From: Beata Ginn <Beata.Ginn@nationalhighways.co.uk>
Sent: 15 February 2023 17:02
To: Andrew Thompson <Andrew.Thompson@Cherwell-DC.gov.uk>
Cc: Planning SE <planningse@nationalhighways.co.uk>; Patrick Blake <Patrick.Blake@nationalhighways.co.uk>; Spatial Planning <SpatialPlanning@nationalhighways.co.uk>
Subject: HOLDING RESPONSE@2023 02 15: (97431) #19085 Planning notification for application reference: 23/00173/OUT Land South Of, Green Lane, Chesterton

Proposal: Outline planning application for up to 147 homes, public open space, flexible recreational playing field area and sports pitches with associated car parking, alongside landscaping, ecological enhancements, SuDs, green/blue and hard infrastructure, with vehicular and pedestrian/cycle accesses, and all associated works (all matters reserved except for means of access).

Location: Land South Of Green Lane Chesterton

Your Reference: 23/00173/OUT

**Image 6.1: Junction Assessment Locations**

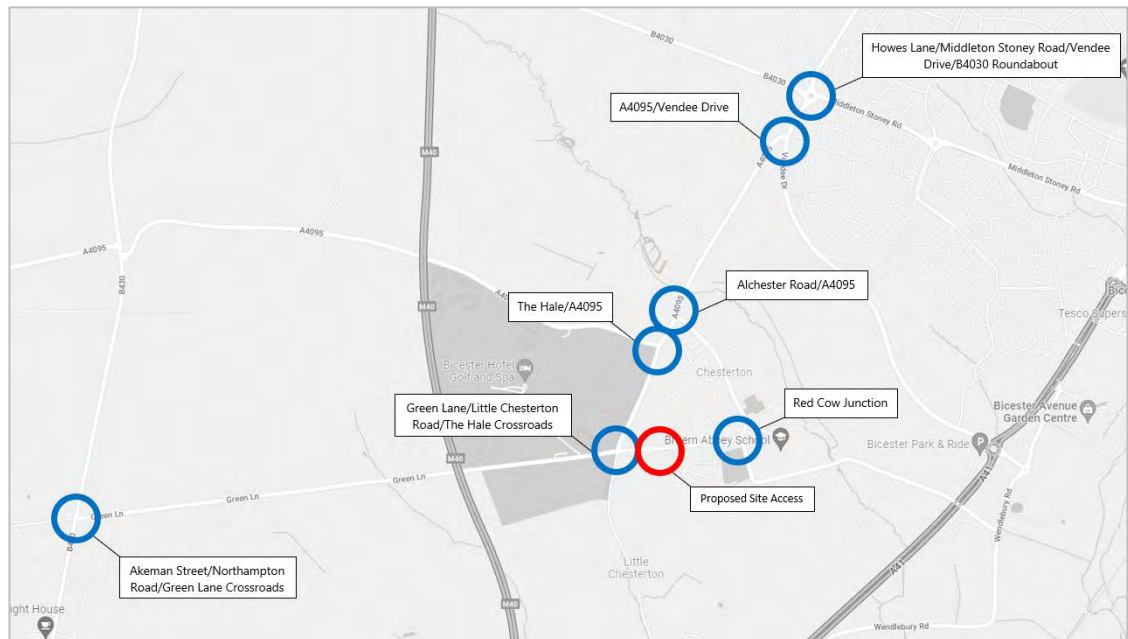
We would be concerned with proposals that may have the potential to impact on the safe and efficient operation of the SRN, in this case the M40 and A34 and in particular, M40 Junction 9, which is located approximately 3 miles from the site and regularly experiences congestion during peak hours.

Given that the application site is not allocated within an adopted local plan, and that it is located close to an SRN junction with existing congestion, we request that the applicant provides AM and PM peak hour distribution flows for all arms of the M40 J9 roundabout. This should show the expected number of development trips leaving/joining the SRN (M40 & A34) at each arm of the roundabout.
